June 1, 2016

Subject: **Revised Permit Modification Request for the Section 404 Individual Permit, Section 401 Individual Water Quality Certification and CAMA Major Development Permit** for the proposed improvements to US 70 from existing four lanes at Radio Island to north of Olga Road (SR 1426), Carteret County, State Project No. 8.1162501, Federal Aid Project STPNHF-70(43), TIP R-3307, Debit \$570 (NCDWR) and \$100 (NCDCM) from WBS 34528.1.1

Please see the enclosed revised permit drawings and impact summary sheet for the above referenced project.

Permit Drawing
Sheet 5a of 34
Revised 26 Aug 2016

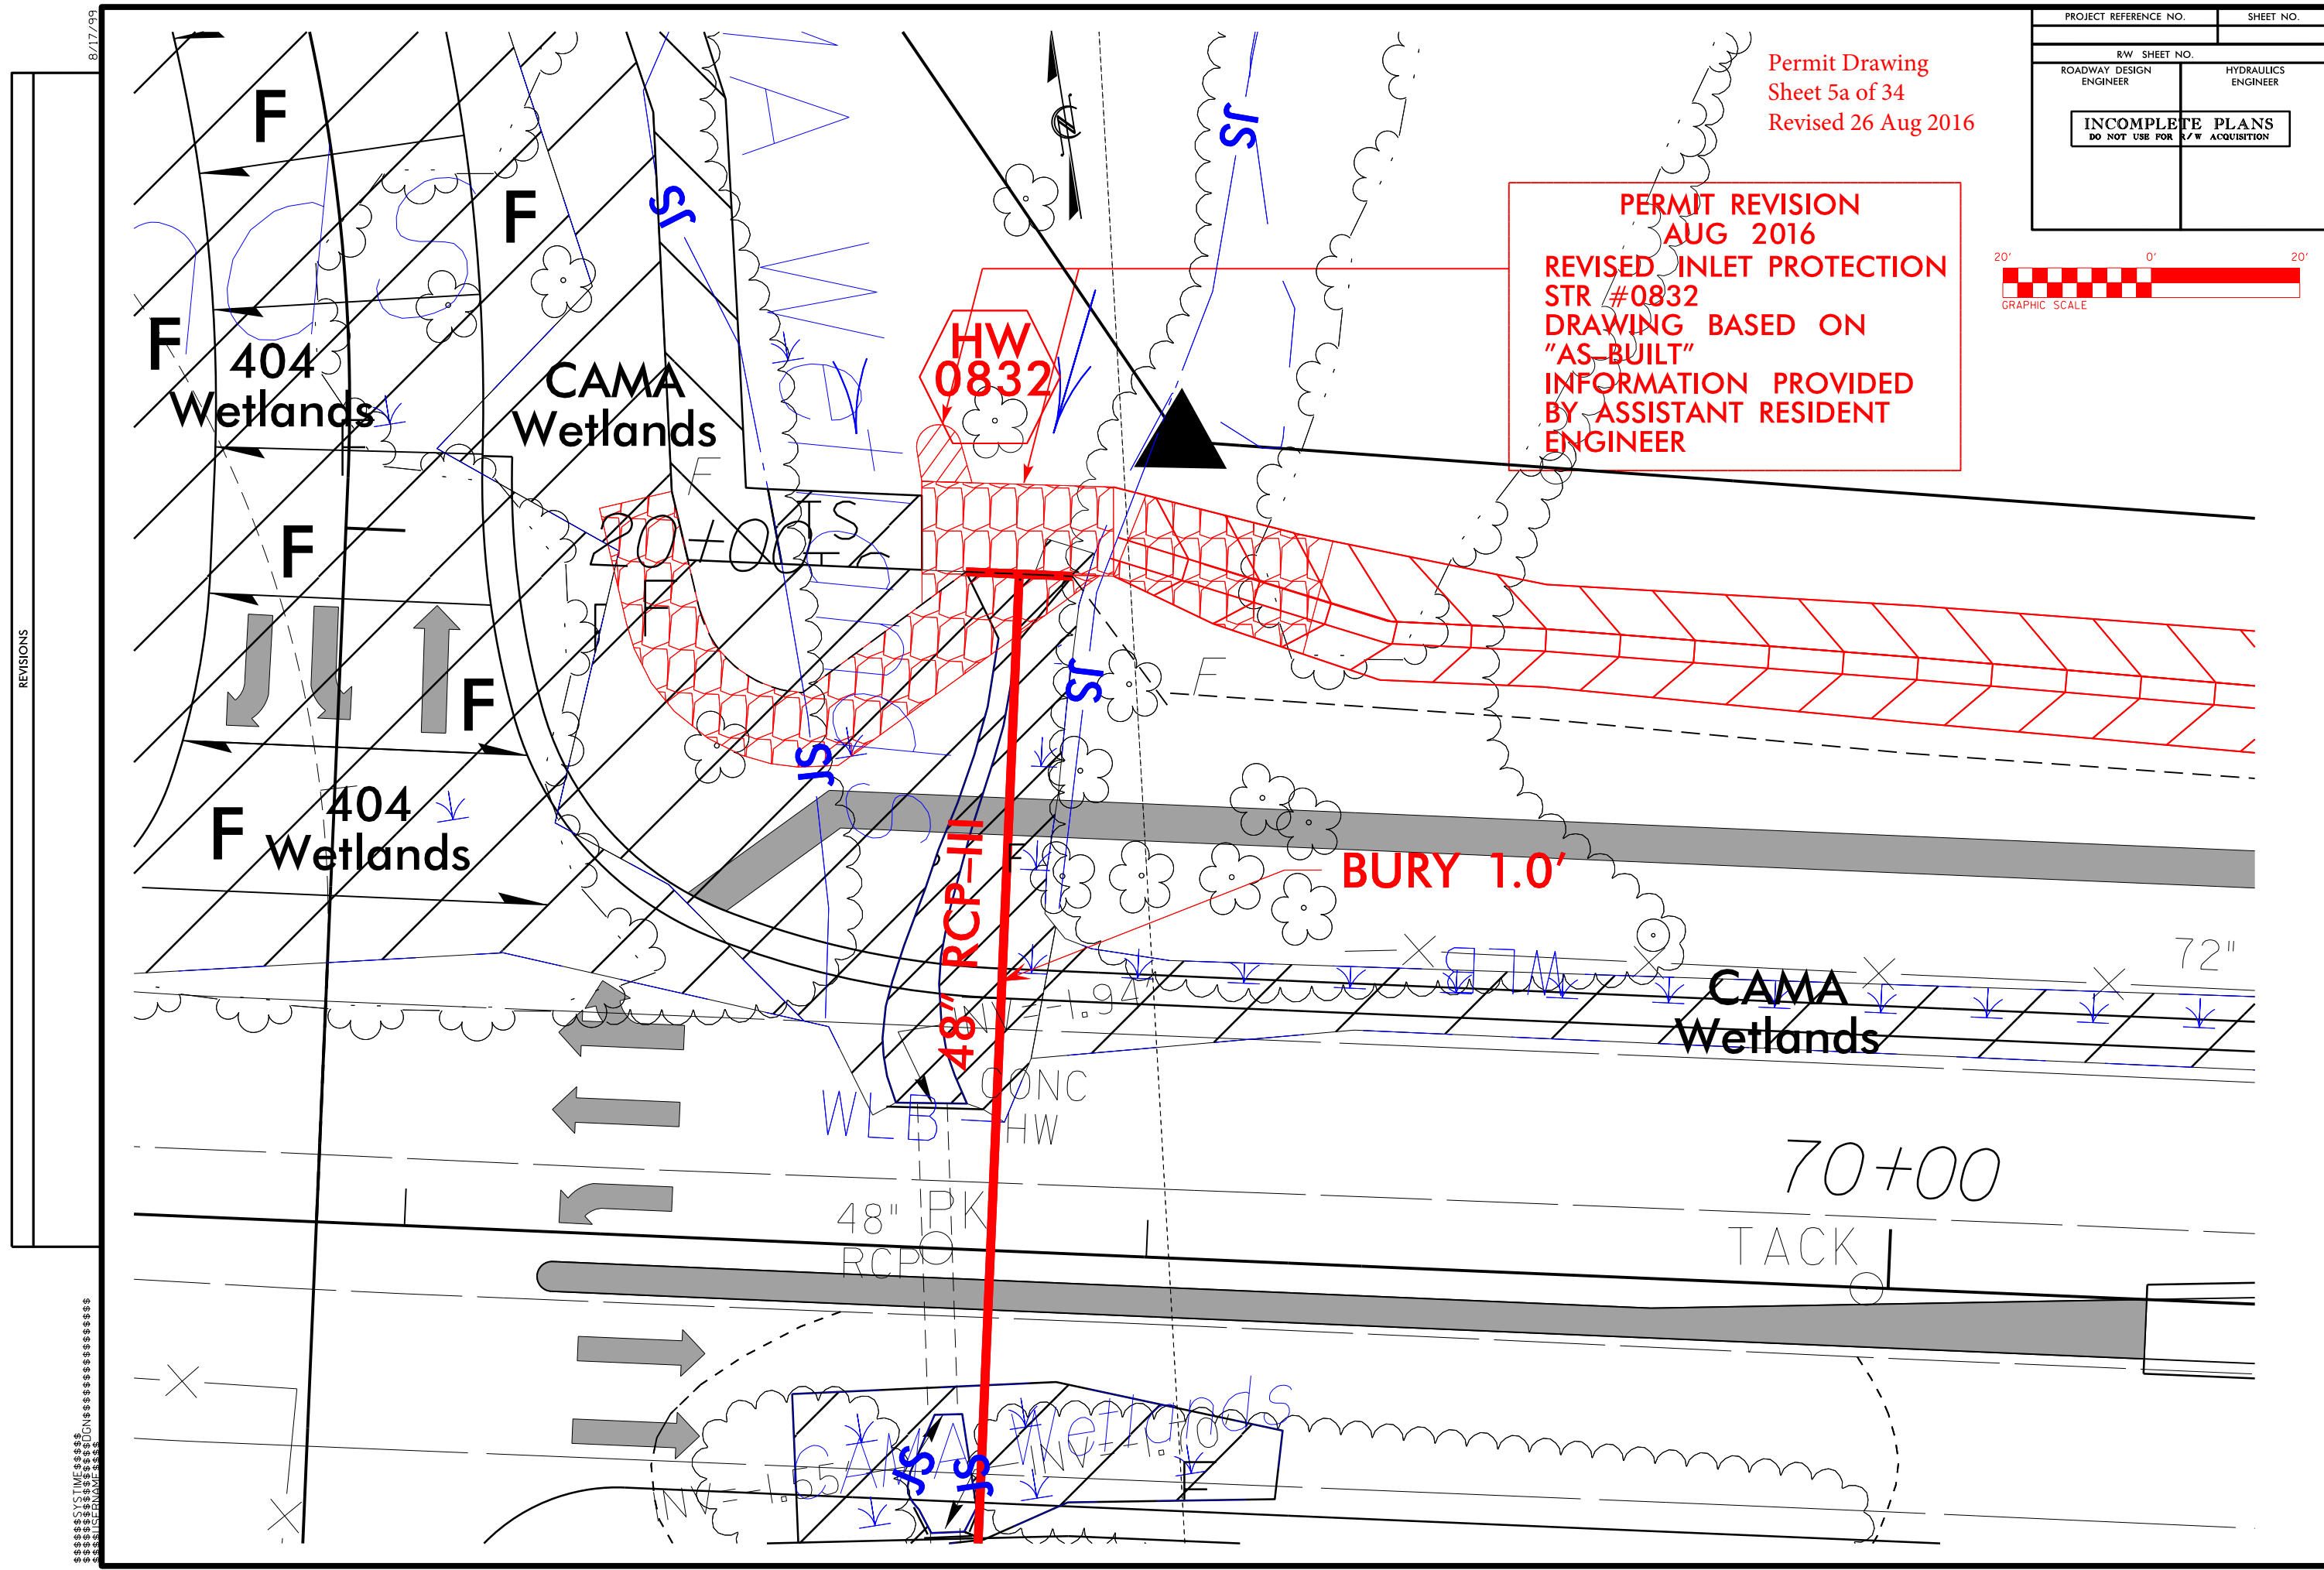
As noted during a recent field review, additional rip rap will be required for the 48" RCP at Site 2 for inlet protection, resulting in an additional 0.01 acre of fill in surface waters. Additionally, a small head cut will be filled with select granular material, matching surrounding grade and transplanted with local grasses.
